# Experience Quarter (EQ)

## Bicester Motion

## Walking & Cycling Infrastructure – Response to OCC

1.1.2 The application has been submitted in outline (ref: 21/01224/OUT) to Cherwell District Council (CDC) as planning authority. Oxfordshire County Council (OCC) has been consulted in their capacity as Highway Authority, subsequently providing an officer response dated 24 May 2021.

**Fig 1, highlighted historical paths from pre-war period**

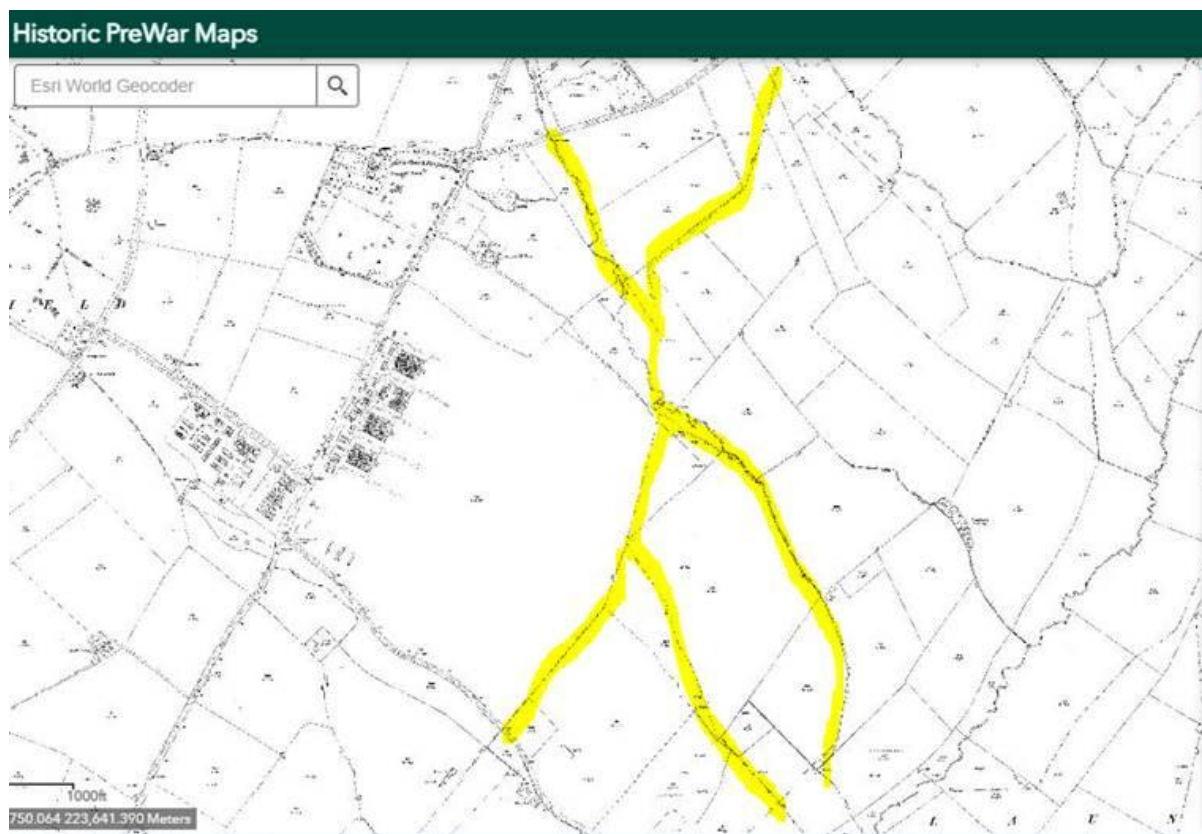
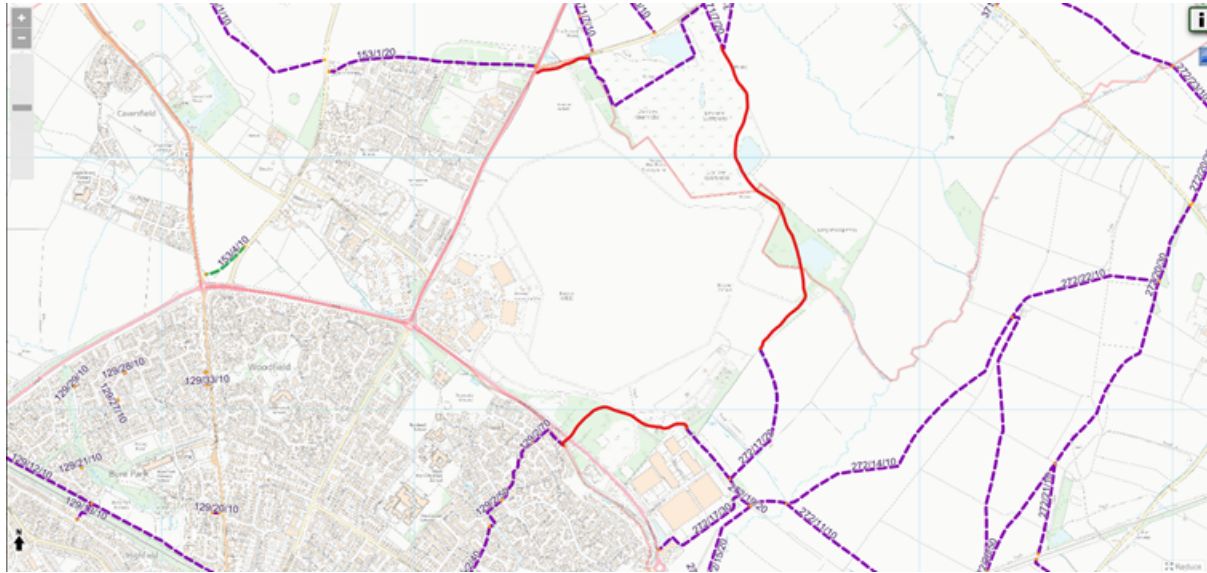
*“The proposal provides no assessment or provision for public rights of way and public access in a way that helps deliver public access benefit to address the impacts of the cross-site public rights of way stopped up pre-war. The site should be made part permeable by reconnecting Public Rights of Way.*

*OCC Public Rights of Way request that the site be made part-permeable through the reinstatement of Public Rights of Way connection that was cut off pre-war.”*

- 1.4.2 Connectivity across the wider Bicester Motion site is something that has been considered as part of the previous and current planning applications, in order to ensure that the development parcels are interconnected and link up efficiently to both the existing and proposed infrastructure along the local highway network.
- 1.4.3 The opportunity for this wider connectivity is ultimately dependent upon the cumulative delivery of the Innovation Quarter, Experience Quarter, Wilderness Quarter and other projects associated with the masterplan. As this is a strategic opportunity more appropriate with the wider cumulative delivery of additional Bicester Motion Masterplan developments, this may therefore be better addressed and considered as part of the final phase of development and planning application.

1.4.4 Connectivity across the wider site is clearly in the interest of Bicester Motion, due to the different functions and inter-relationship between the various phases of development; it is intended that the Experience Quarter will enable controlled public access throughout the site – although, this must be ‘controlled’ in certain areas/elements, due to the active airfield. However, it is also noted that this PRoW request is an aspiration on the part of OCC, and not necessarily required in order to make the development ‘acceptable’ on its planning merits – therefore, not CIL compliant.
